KITITAS COUNTY

TO: Dusty Pilkington, CDS
FROM: Kelly Bacon, Engineer Technician I *KB*
DATE: December 9, 2016
SUBJECT: Swauk Valley Ranch BL-16-00012

Public Works Planning Review of Preliminary survey for Swauk Valley Ranch BL-16-00012

County Survey review of Swauk Valley Ranch (BL-16-00012)

SHEET 1

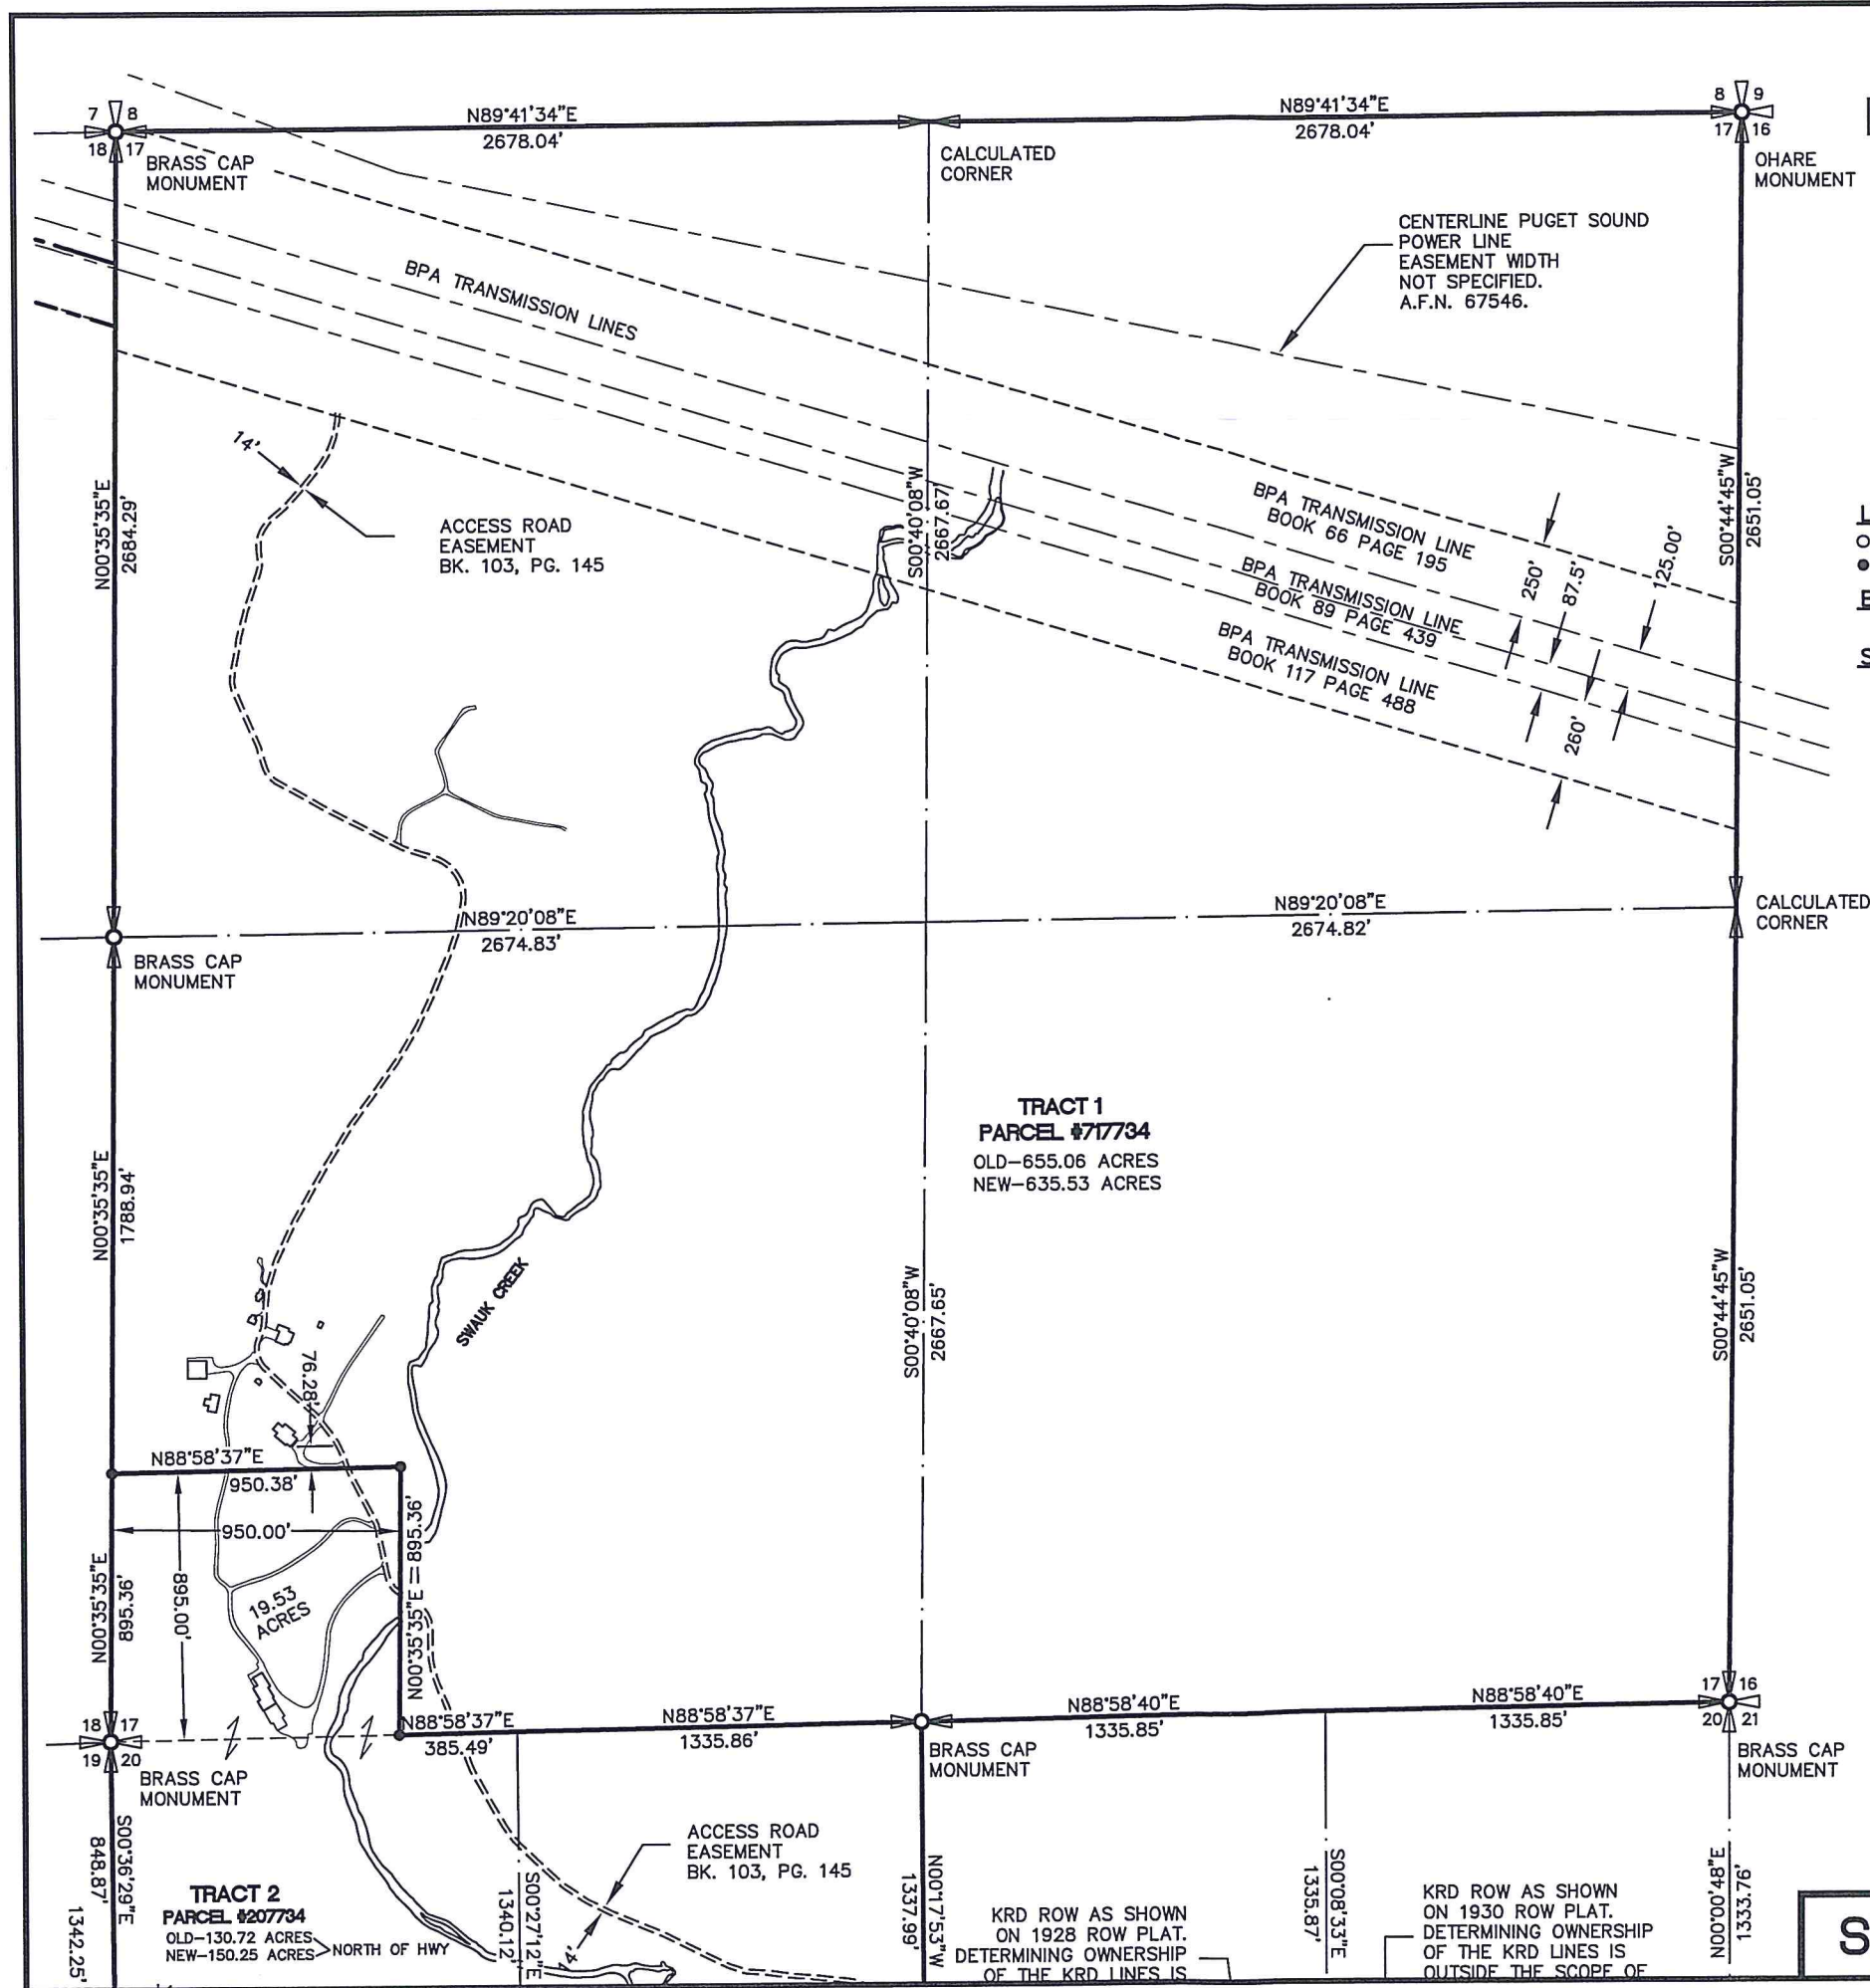
5. The following labels on sheet 1 are clipped or obscured by linework. (all located along the south edge of Sheet) 1342.0?, N00-17-53?, S00-08-33E.
6. The following labels on sheet 2 are clipped or obscured by linework.
L16,L18,S88-47-26W
